ACP-324165-26 – Maughanaclea Wind Farm

Maughanaclea Renewable Energy Development

Case Reference: 324165

RESPONSE TO SECTION 4.3.2 — NATURE CONSERVATION

All eDNA results can be found in Appendix III. Freshwater Pearl Mussel eDNA results for survey sites are shown in Figure 4-1.

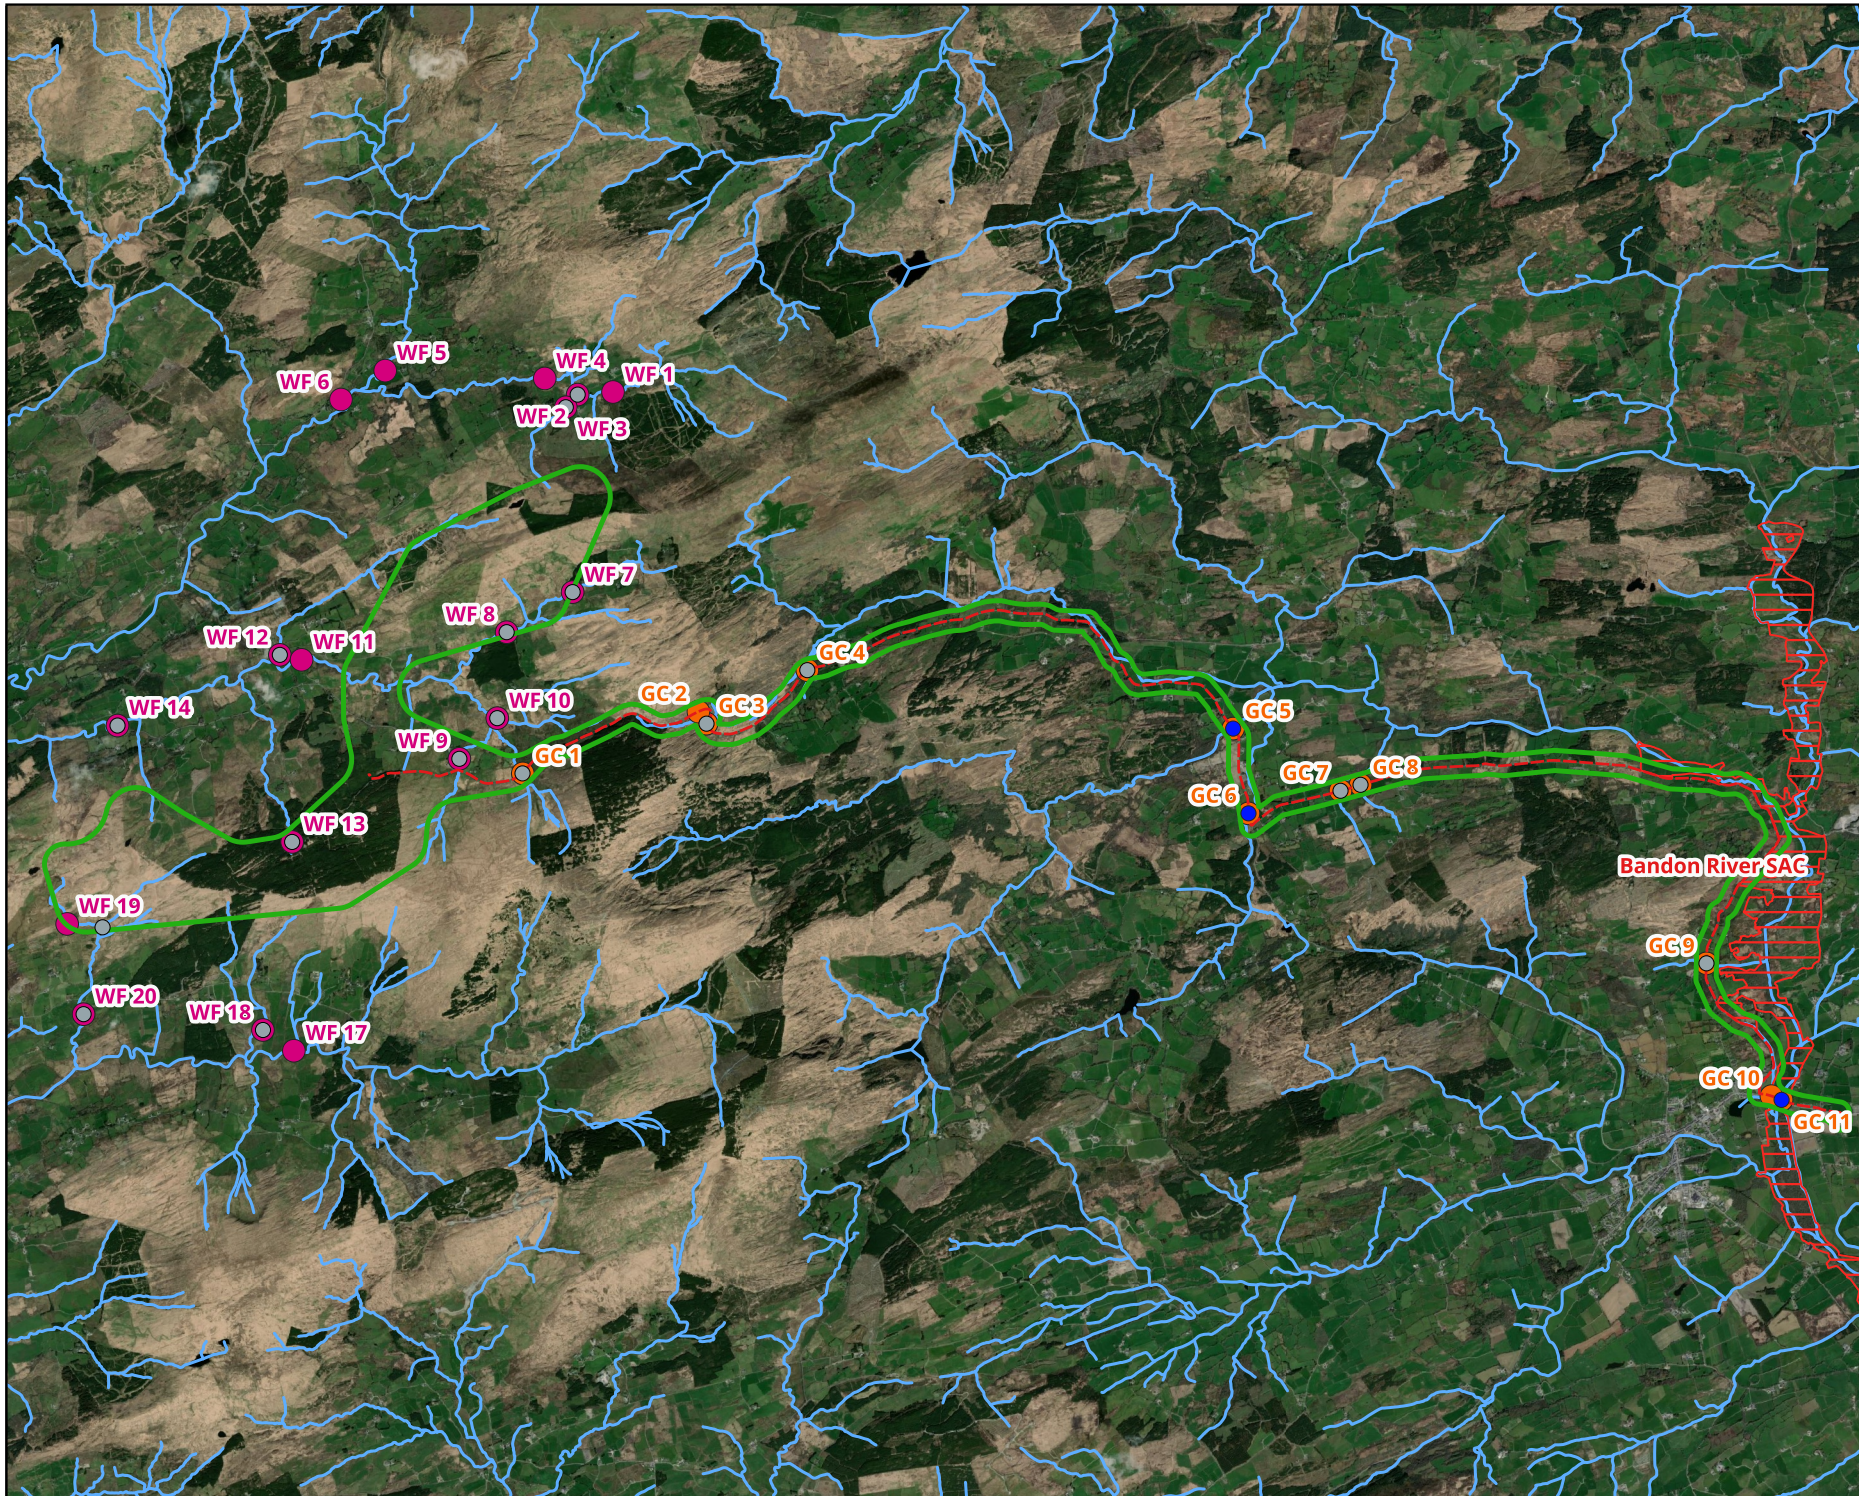
Freshwater Pearl Mussel was detected at GC5, GC6 and GC11, with 12 out of 12 positive replicates at GC5. A potential ecological pathway to Bandon River SAC is therefore clearly identified.

1. the predicted sediment mobilisation associated with the grid connection works;
2. the specific risks associated with HDD crossings;
3. the potential consequences of HDD drilling-fluid breakout;
4. monitoring locations and trigger levels;
5. emergency response procedures; and
6. how the positive Freshwater Pearl Mussel eDNA findings have been incorporated into the risk assessment.
